I wish to make Objections and Comments on Application 2026/91763 Land Off Barnsley Road Denby Dale HD8; 40 Dwellings

SITE LAYOUT PLAN - 2530-SI-02H
BARNESLEY ROAD, DENBY DALE
NEWETT HOMES
SCALE:1:500@A1 - AUGUST 2025

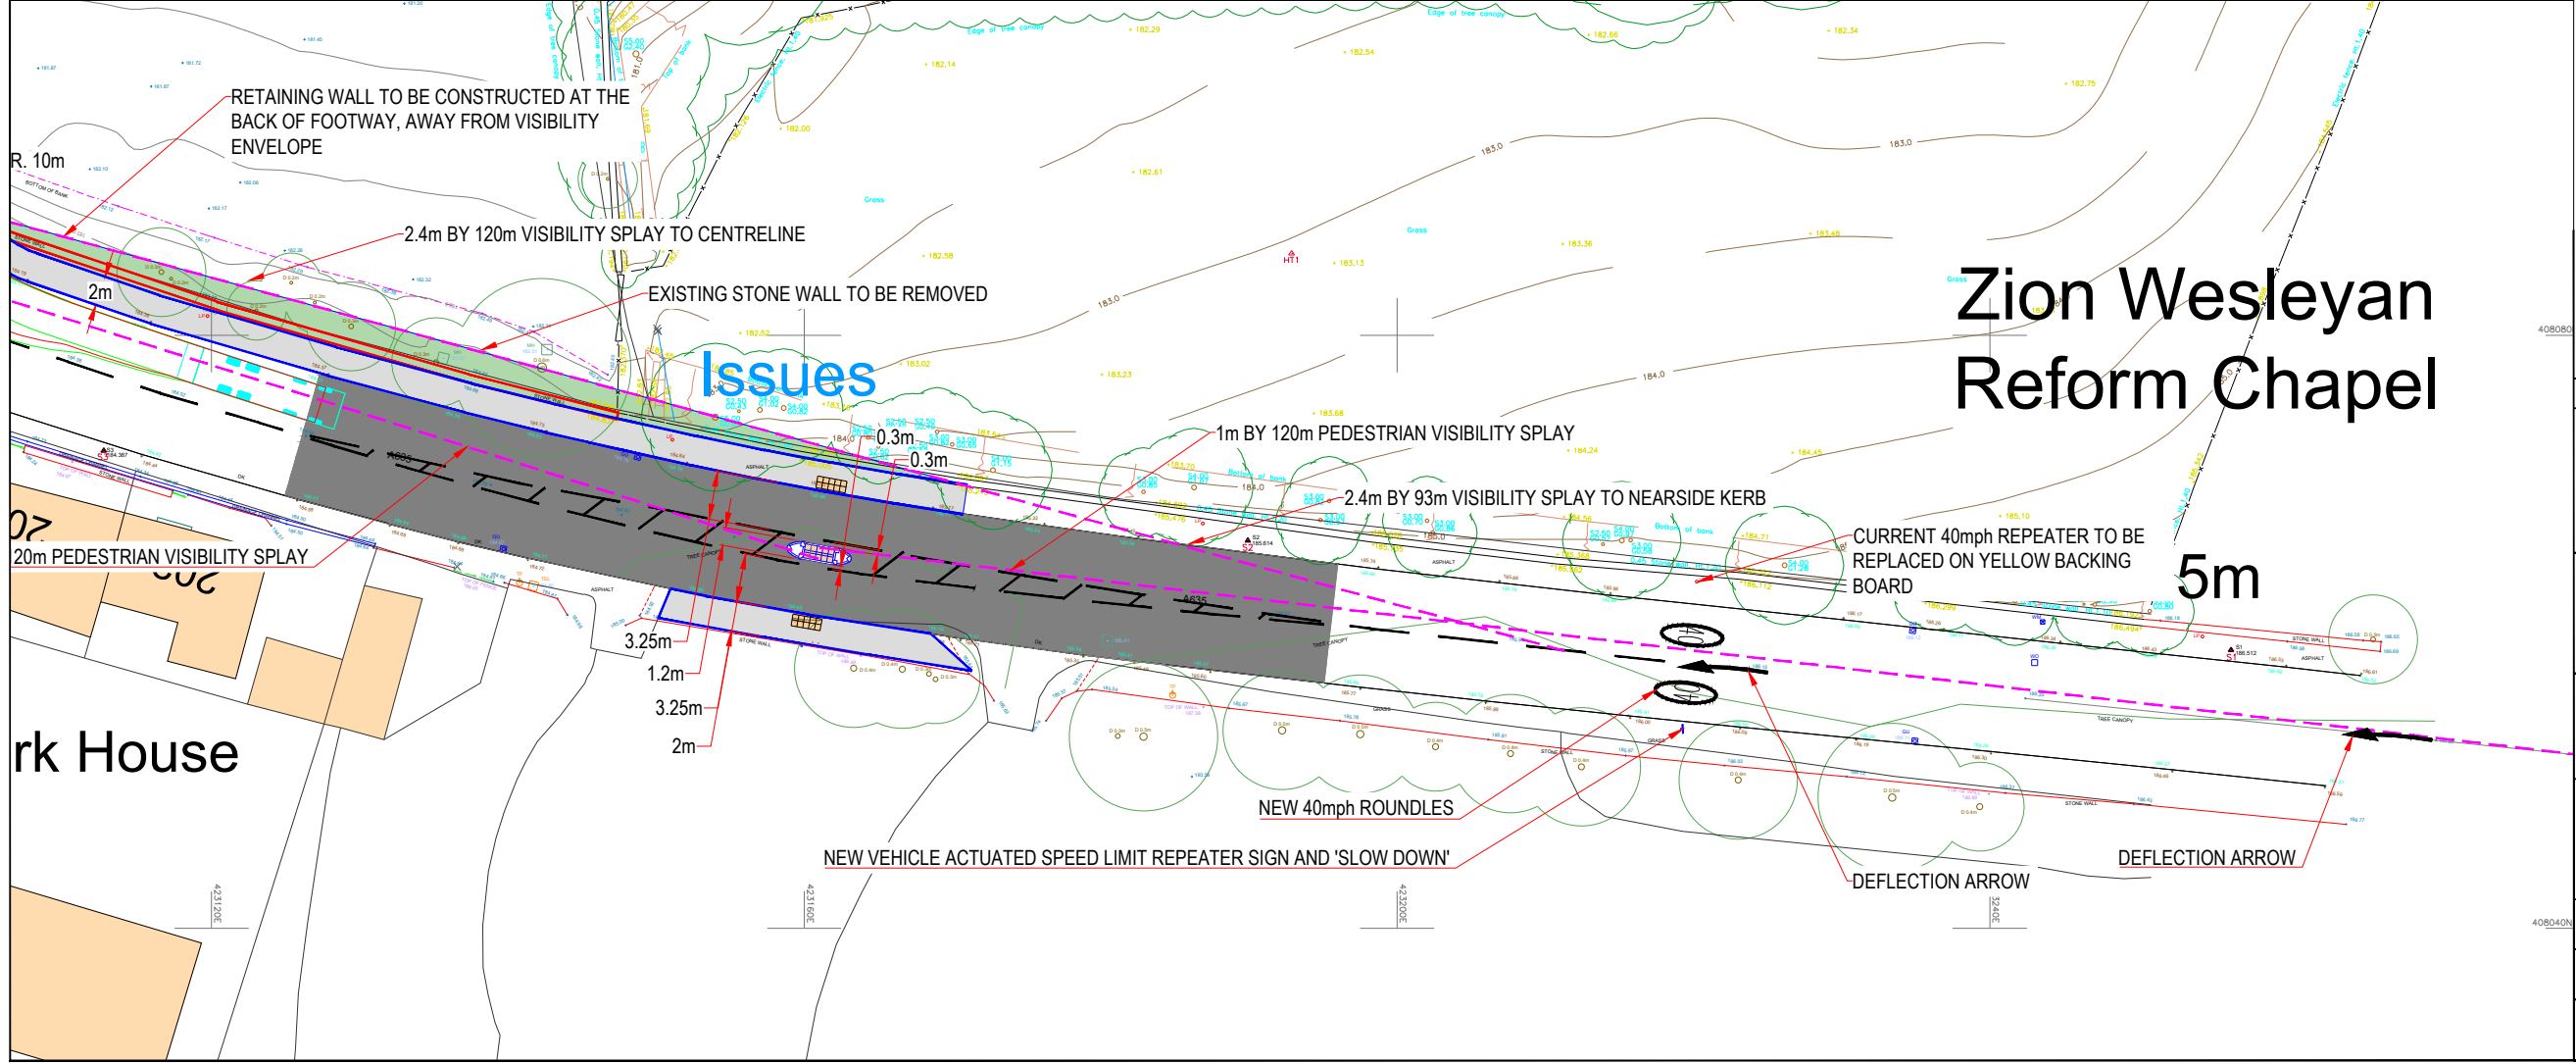
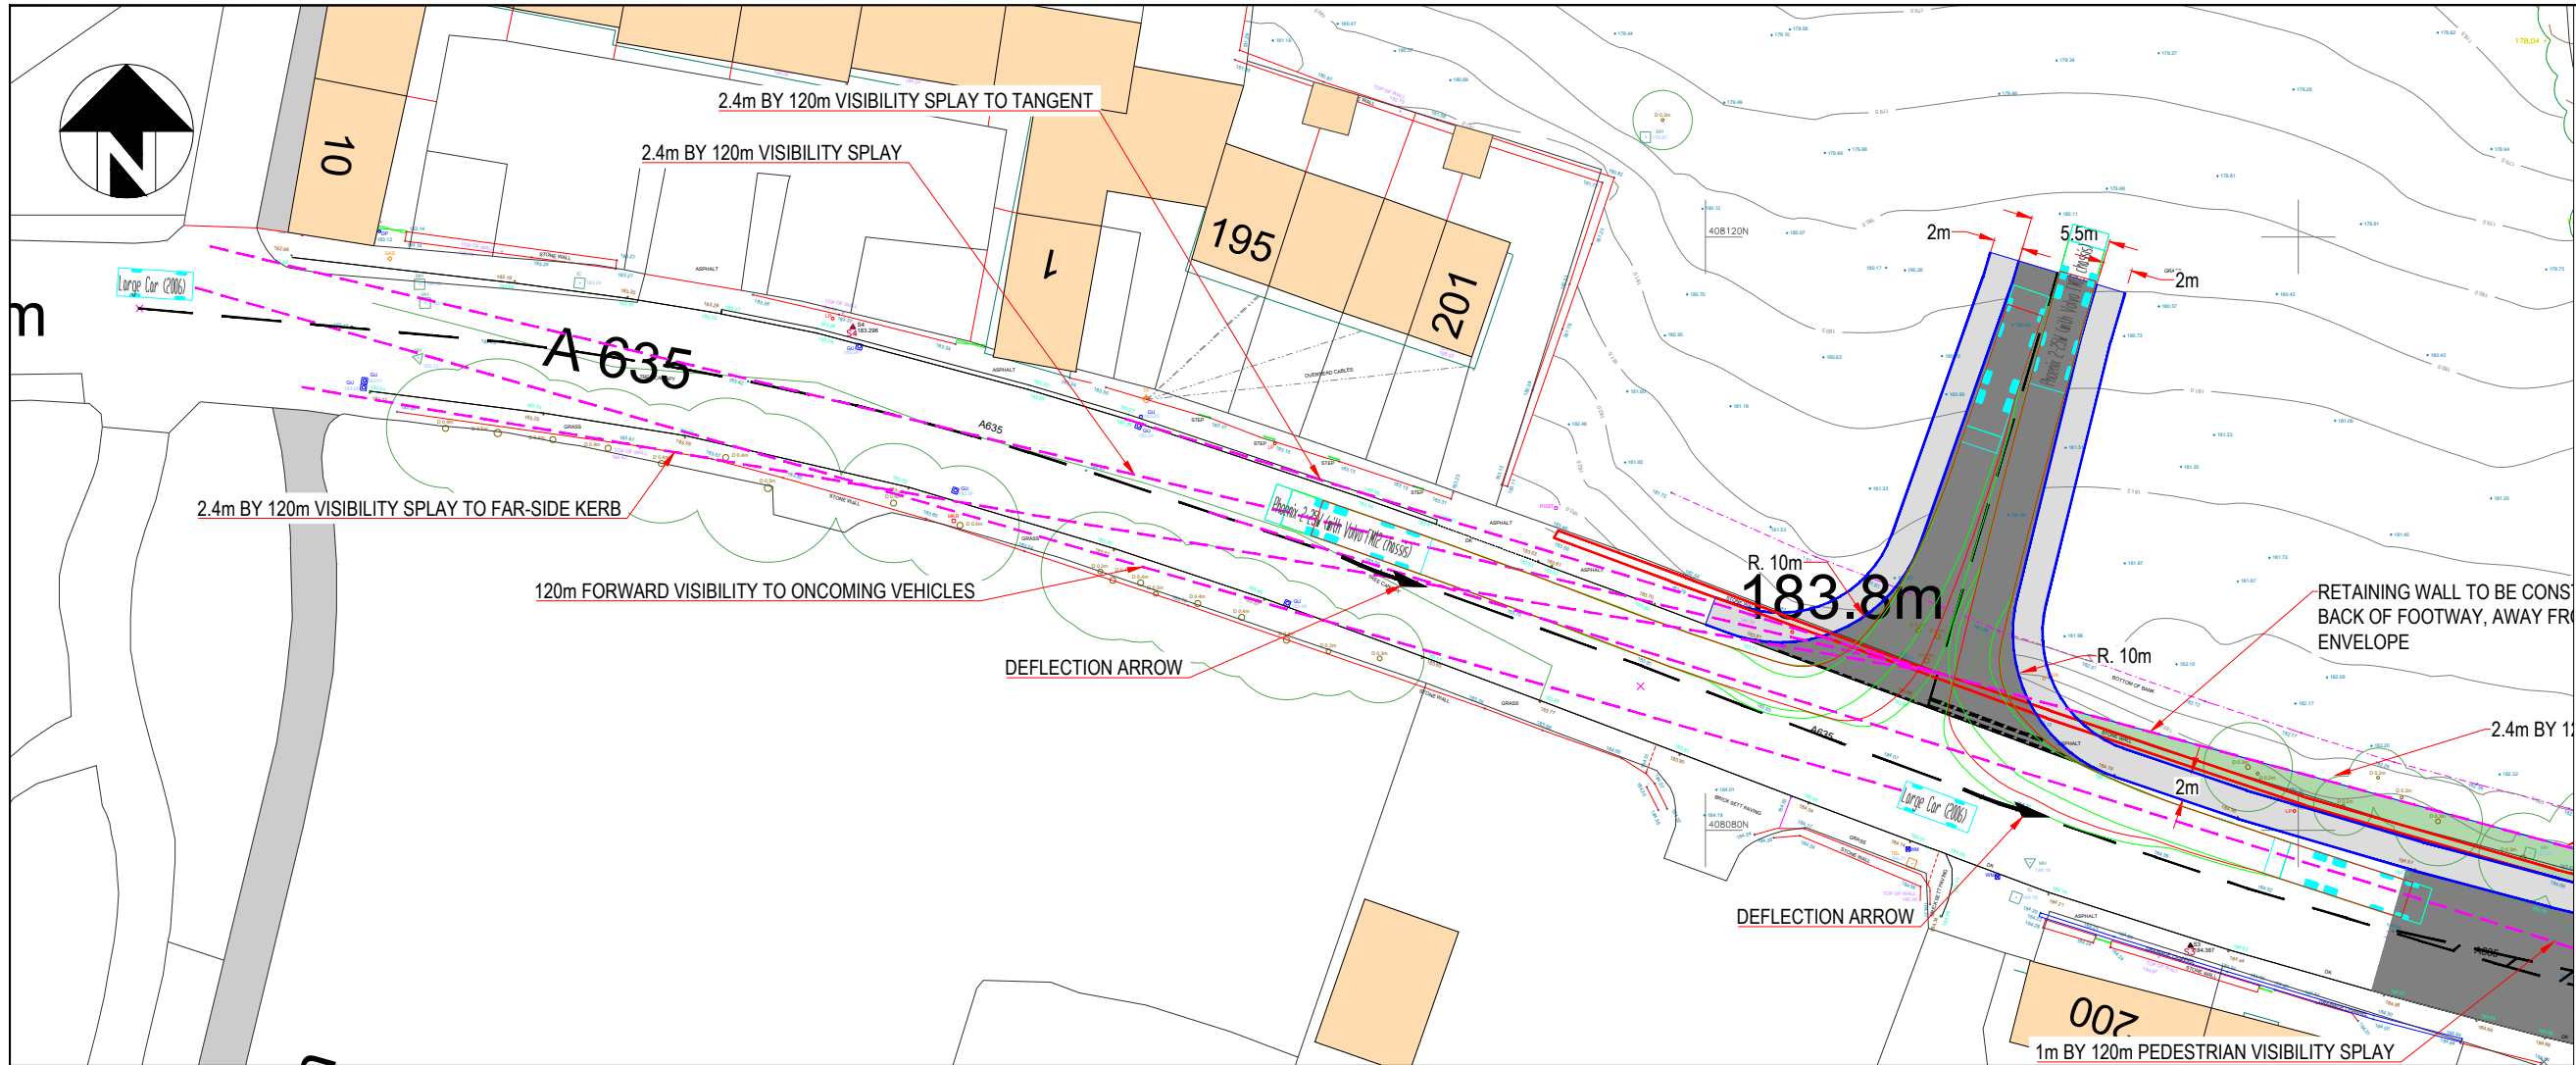
The Site Boundary to the west is adjacent to a public footpath, the existence of which is not included in all the plans. The Habitat Retention Plan shows it as being 'enhanced', with the Landscape Masterplan showing a 'species rich grassland'. It is not clear how this small area can be called that, nor how it will be maintained. It appears that there will be direct access to the footpath from the site from the amenity green space via a 0.45m knee rail. Unless it is properly maintained, the grassland will conceal this rail and create a trip hazard. I would suggest that if the development were approved, provision needs to be made to protect the footpath and give safe access to it both during and after construction.

The Sycamore tree T46 is a medium sized tree next to the footpath, described in the application as twin stemmed. However, on walking past last Winter, I noted that one of the stems is clearly dead, and needs removing, irrespective of the outcome of this Application. If the dead stem was not removed it could be a danger to footpath users, and to children climbing it.
